LETTER OF INTENT

MAYBERRY PHASE 2 PUD

**PUD DEVELOPMENT PLAN & PRELIMINARY PLAN
PUDSP251**

Submittal 2: June 15, 2026

VILLAGE MAIN STREET COMMERCIAL SECTION A-A
 APPROVED WITH MAYBERRY PHASE 1 PUD
 DESIGN SPEED: 30 MPH
 (URBAN LOCAL ROADWAY)
 SCALE: 1" = 5'

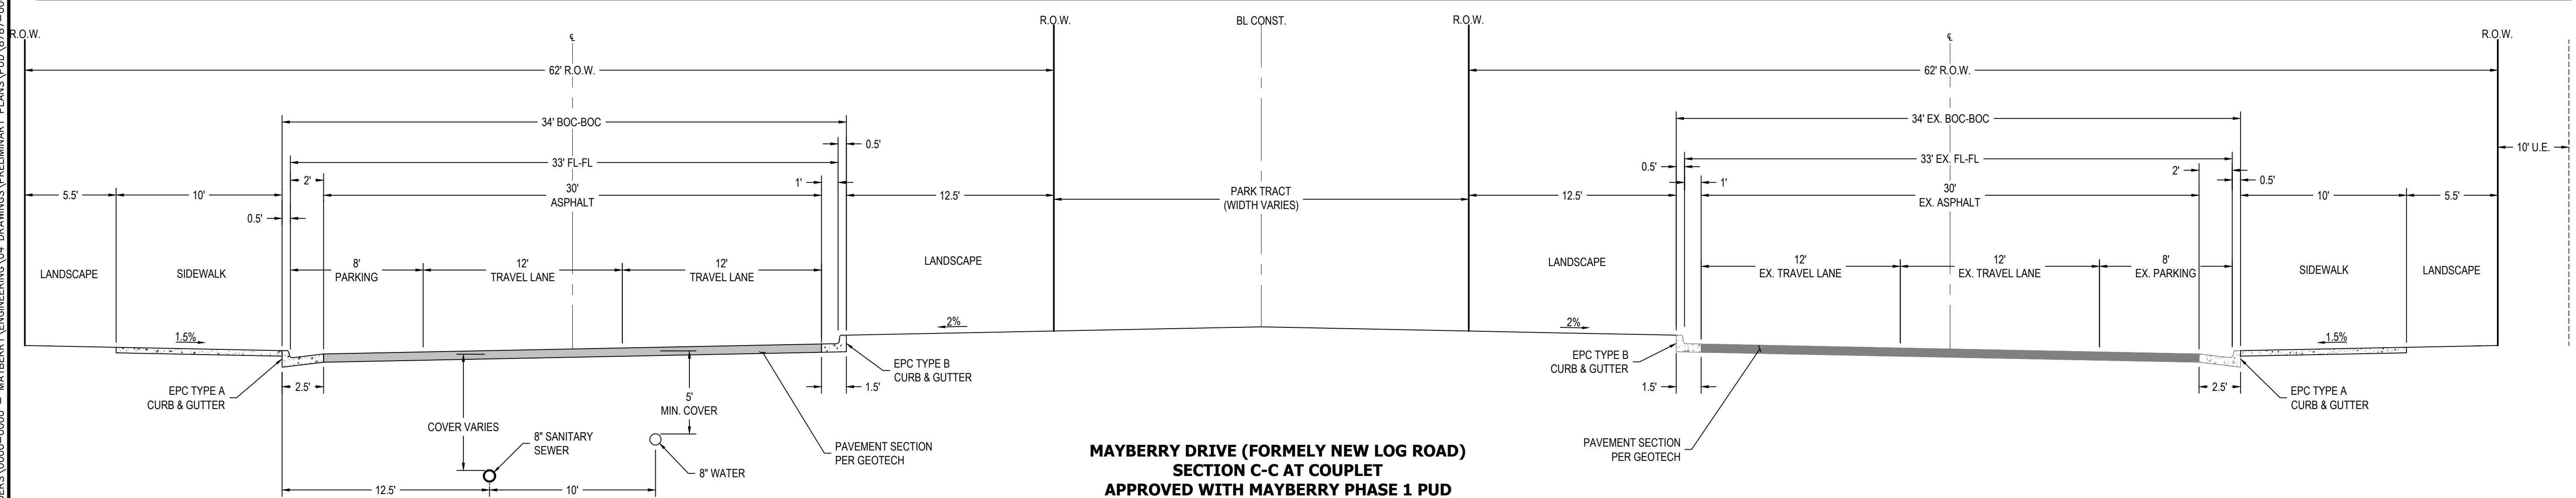
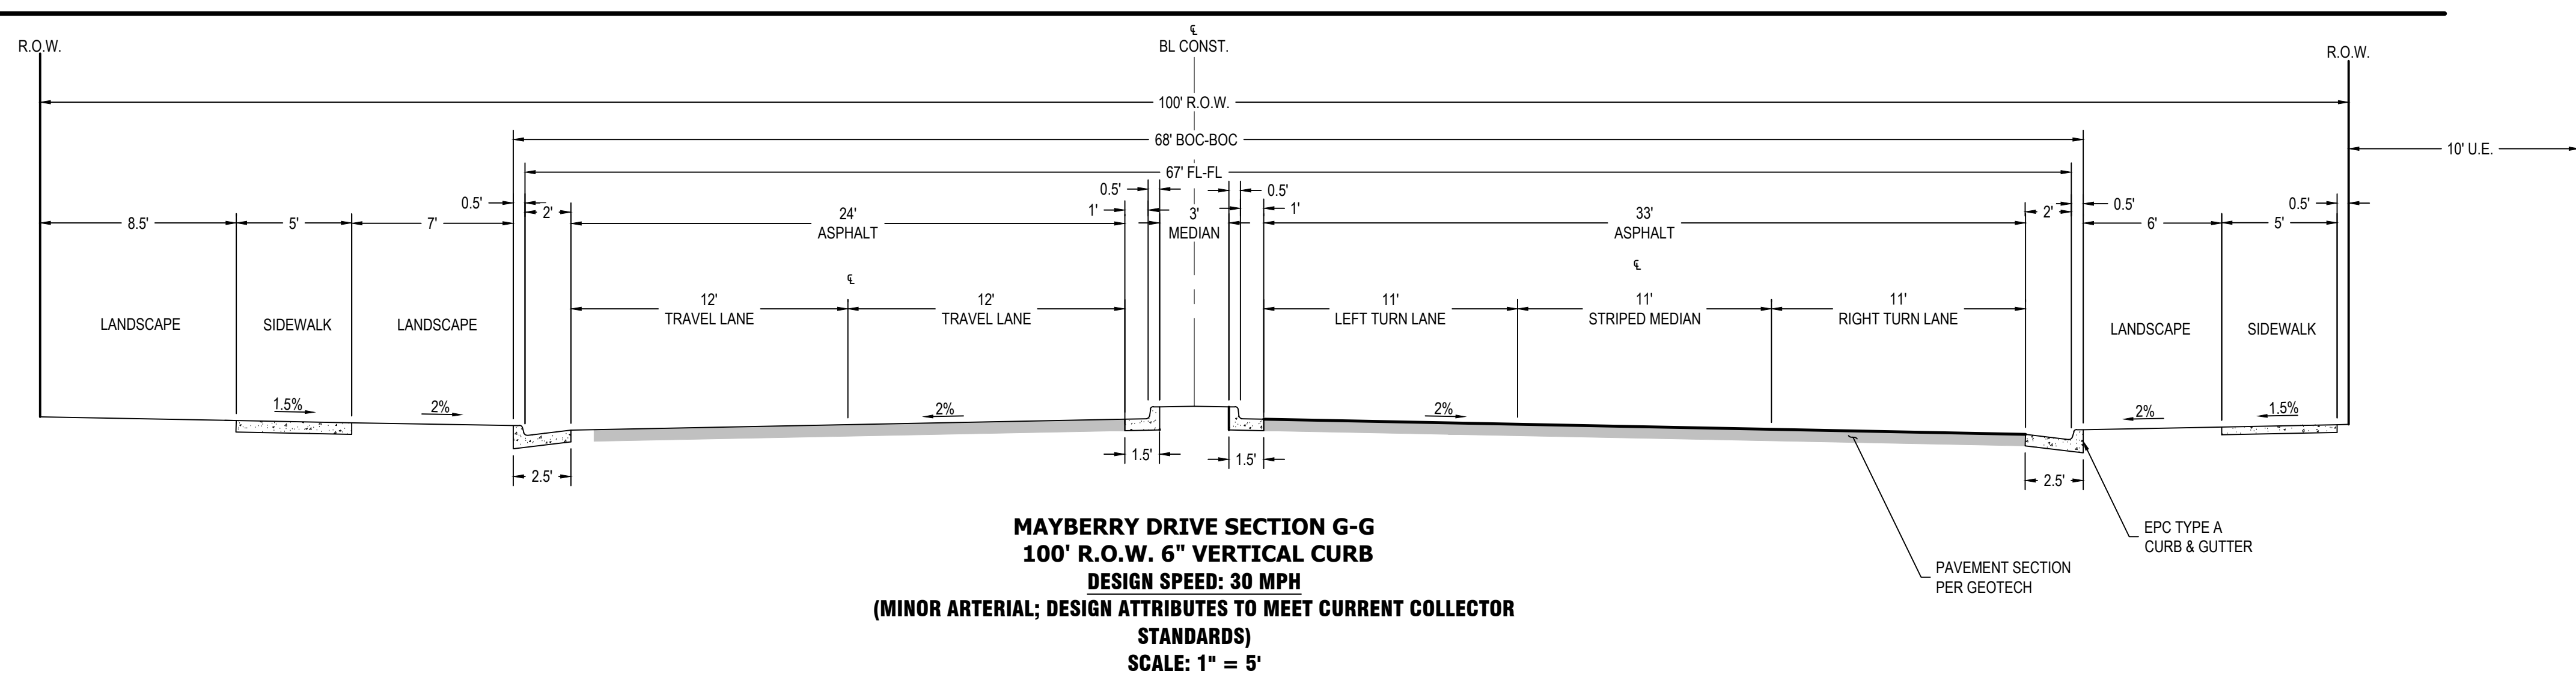
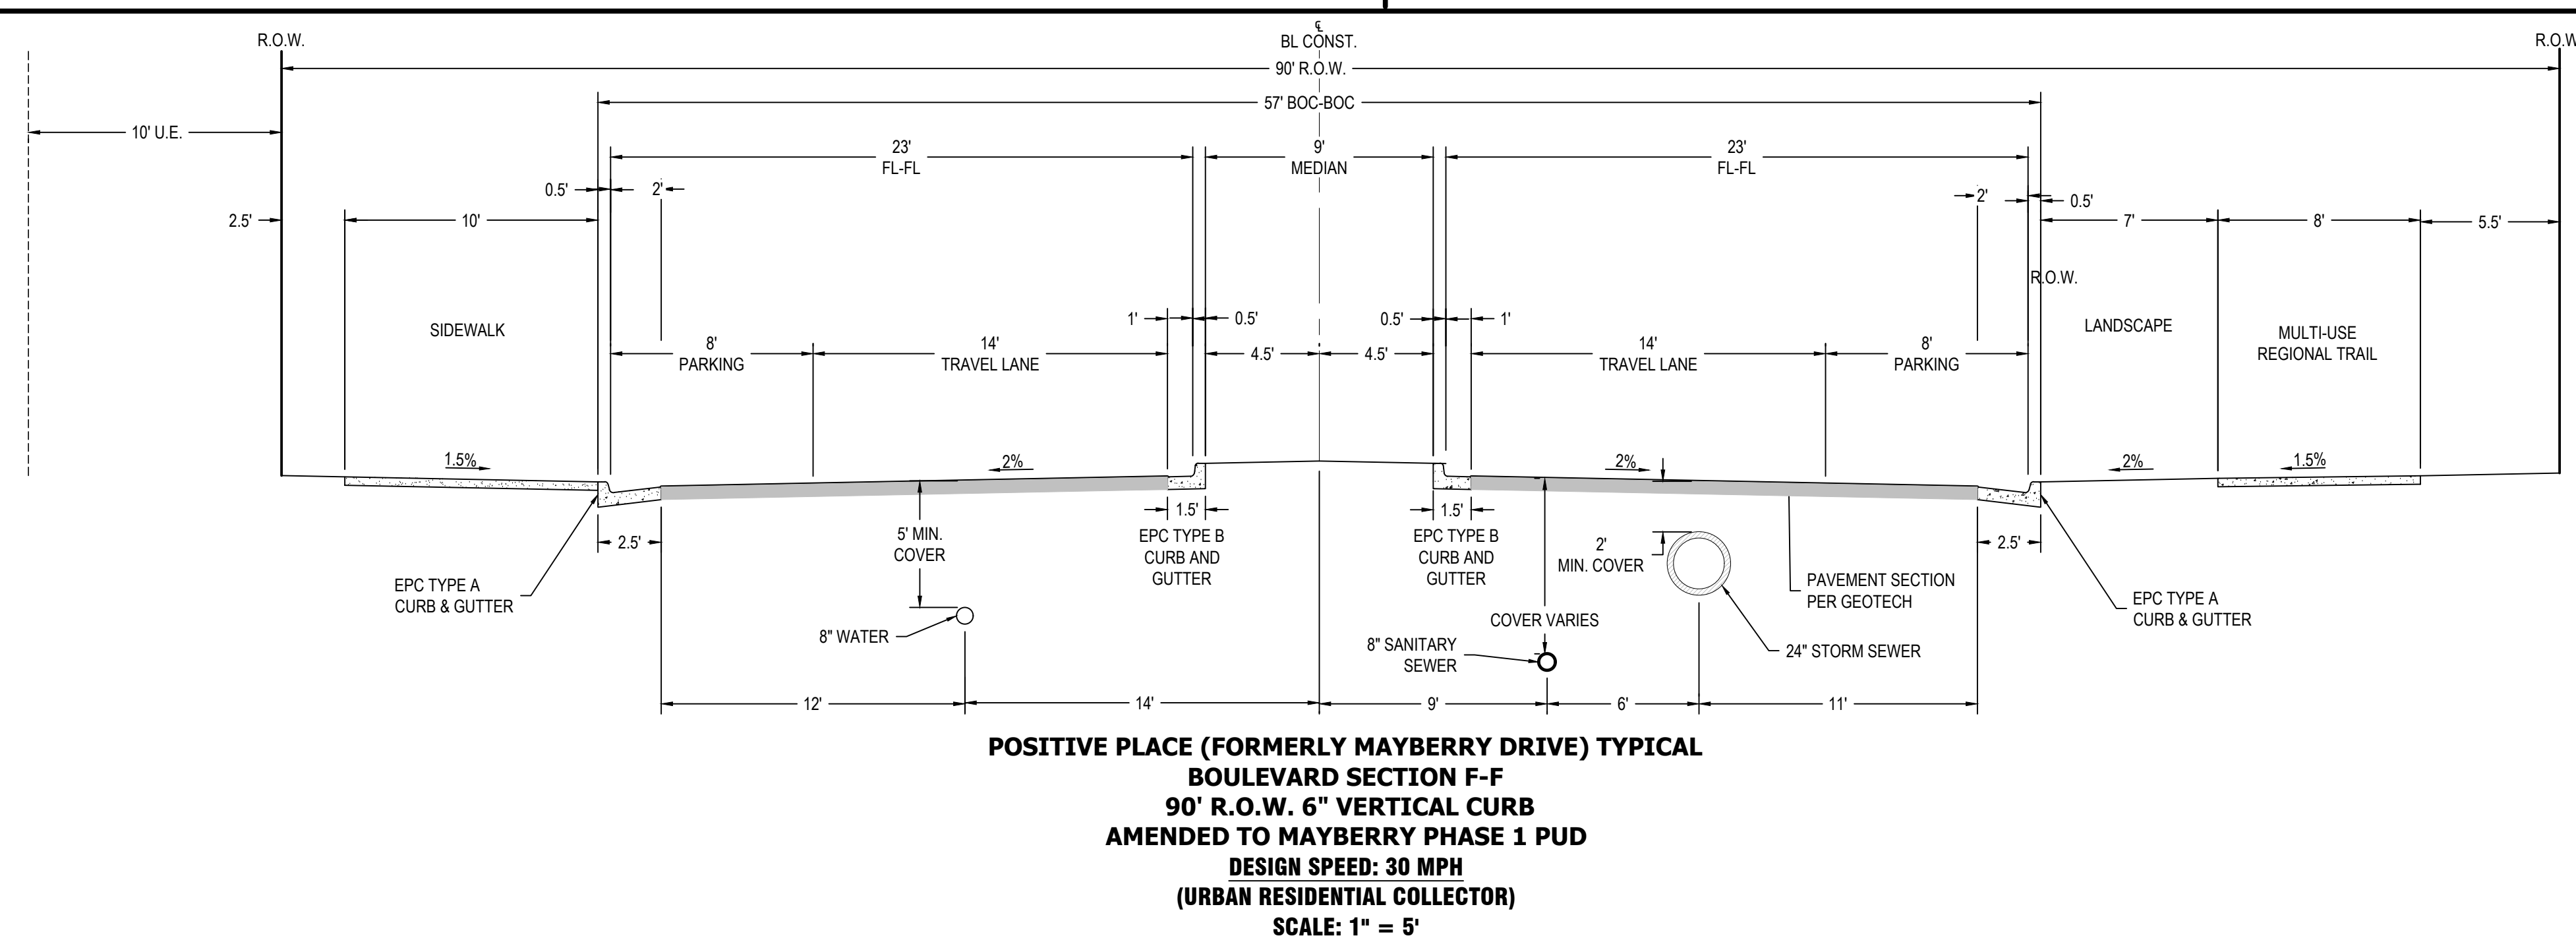
Revise statement. Roads are not meeting county requirements, hence the deviations which are being requested.
